From: Contact Centre (CRM) <contact@ribblevalley.gov.uk>
Sent: 19 January 2026 19:53
To: Planning
Subject: Planning Application Comments - 3/2025/1003 FS-Case-787972016

Planning Application Reference No.: 3/2025/1003

Address of Development: Goose Hillock Cottage
Copster Green
Lancashire

PROPOSED NORTH WEST ELEVATION
Scale 1:100

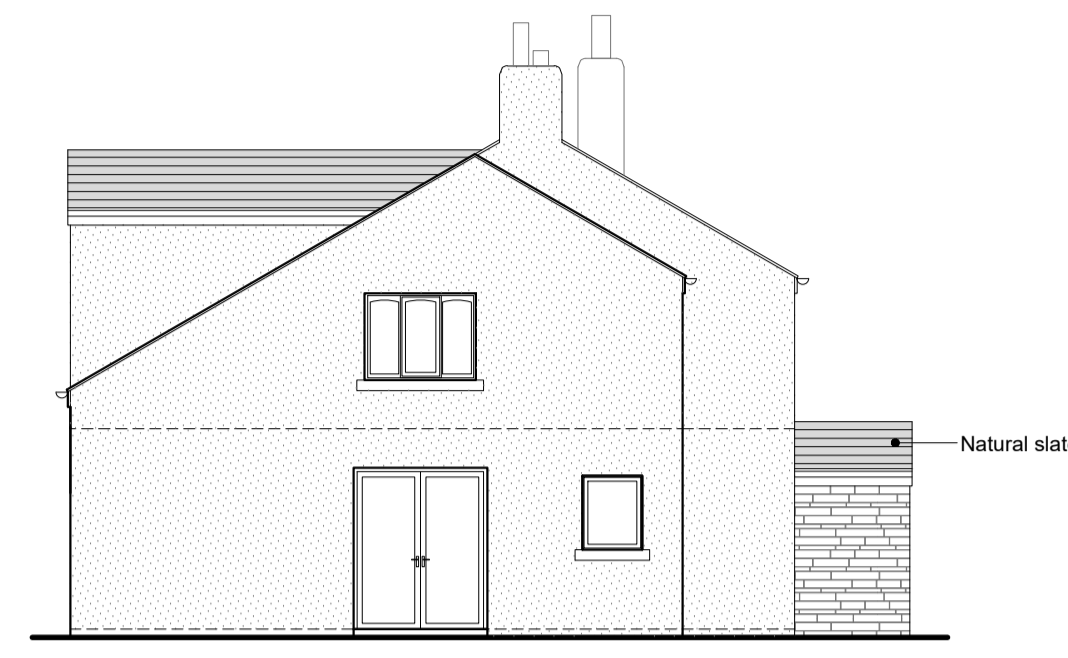
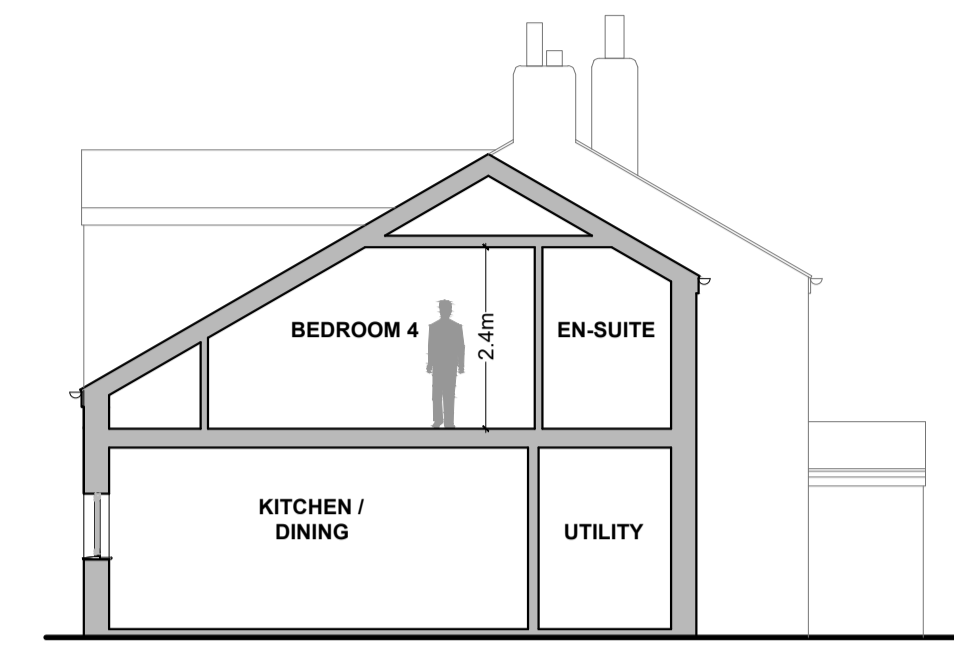
Comments: I am concerned that the proposed alterations amount to the effective loss of the original 19th-century cottage. The removal of the existing stone roof and its replacement with slate appears to be an attempt to blur the distinction between old and new, which would result in the loss of the building's historic character. These historic buildings should be retained and their significance clearly expressed, with a visible and honest juxtaposition between the original structure and any new interventions, rather than an approach that seeks to obscure the past. A more appropriate solution would be a sympathetic extension using a clearly different material, allowing the historic fabric to remain legible and respected.
